Town & Country Planning Act 1990 (as amended)
Town and Country Planning (Development Management Procedure) (England) Order 2015
Approval of details reserved by conditions imposed under P/107/16/PL relating to conditions 3-
surface water drainage, 4-schedule of materials & finishes, 5-landscape scheme, 6-screen
wall/fence details, 8-site set up during construction, 10-storage of waste & recycling details , 11-
placement of 2 No. nesting opportunities for birds & 14-external lighting details.
7 Webb Close Pagham,,

Notification regarding the above application:

Condition Number 4

17017-103^A

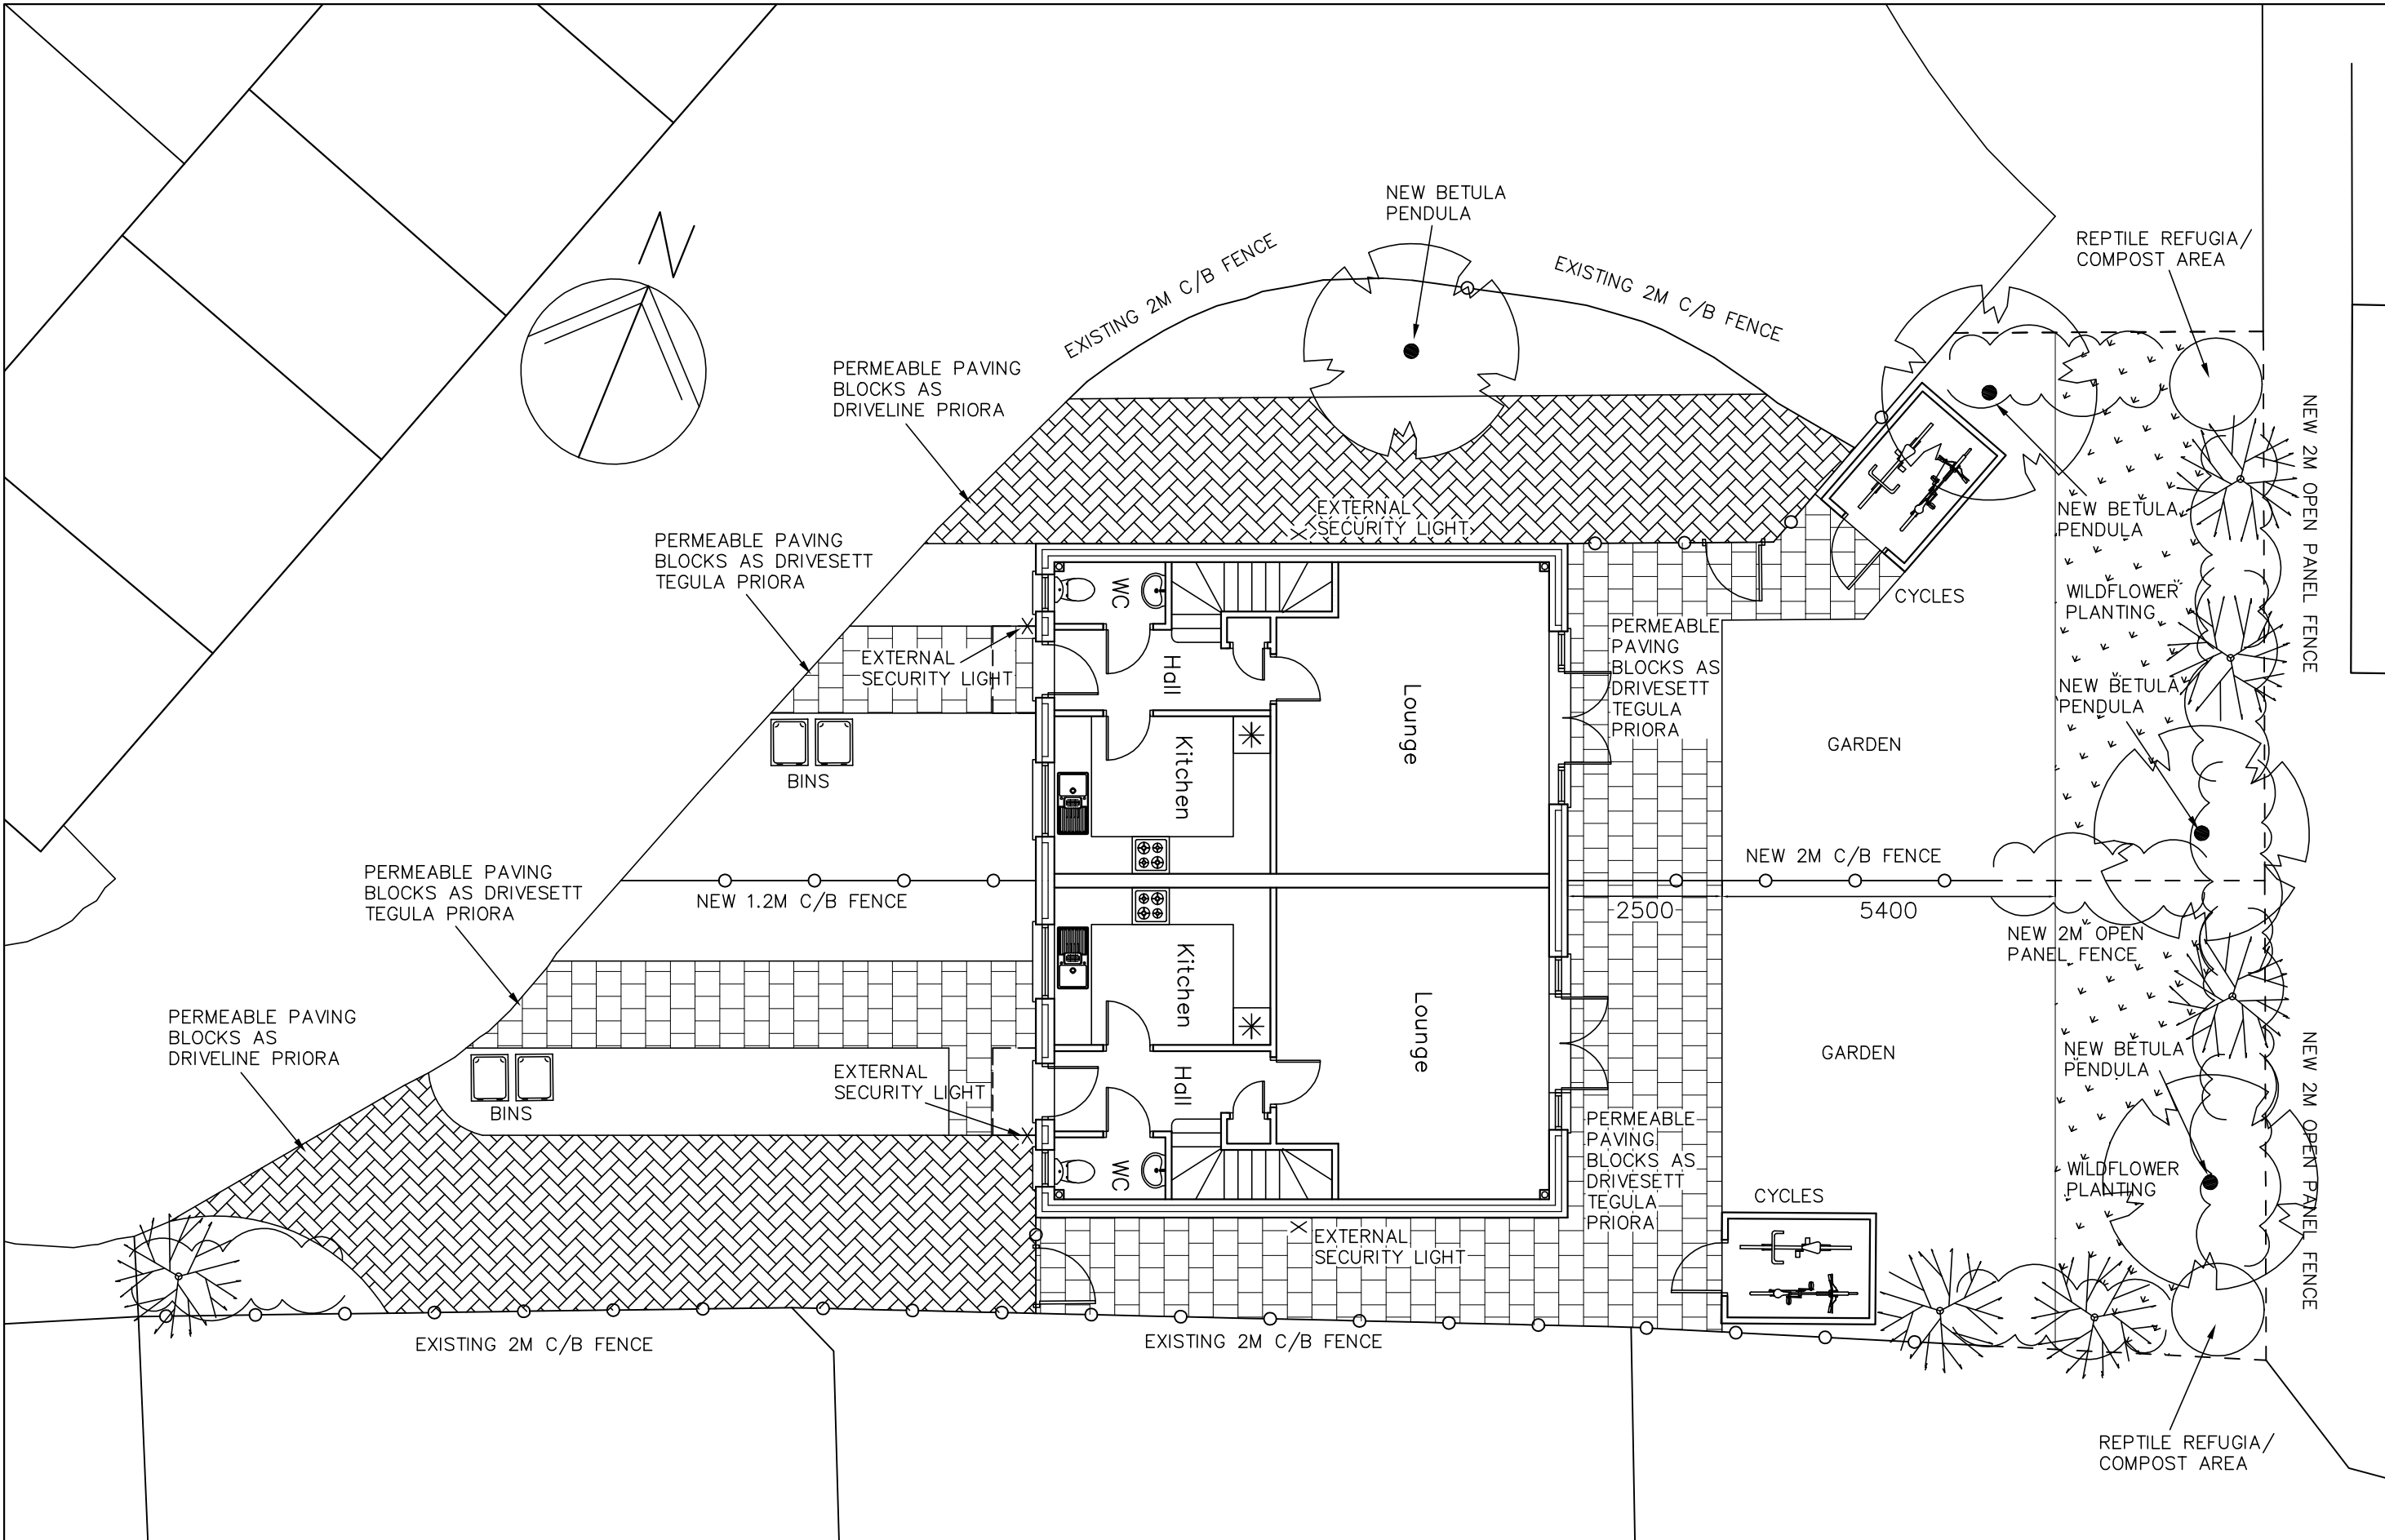
The details submitted in respect of the external surfaces of the walls and roofs of the proposed two dwellings and the hard surfacing around the dwellings, namely the following items, are considered to be acceptable having regard to the character & appearance of the surrounding area. It is also noted that the wall & roof materials proposed are the same or similar to those on the approved application form.

- (1) Ibstock Funton Orchard Mixture to external walls;
- (2) Forterra Clumber Mixed Red to soldier courses;
- (3) Marley Eternit Plain Tile in Old English Dark Red to roofs;
- (4) Marshalls Driveline Priora in Charcoal to permeable paving; and
- (5) Marshalls Drivesett Tegula Priora (Traditional) to patio & pathways.

The position of proposed hard surfacing is shown on the submitted Site Plan drawing 17017-103 Rev A.

Arun District Council have decided to **APPROVE details reserved by this condition**
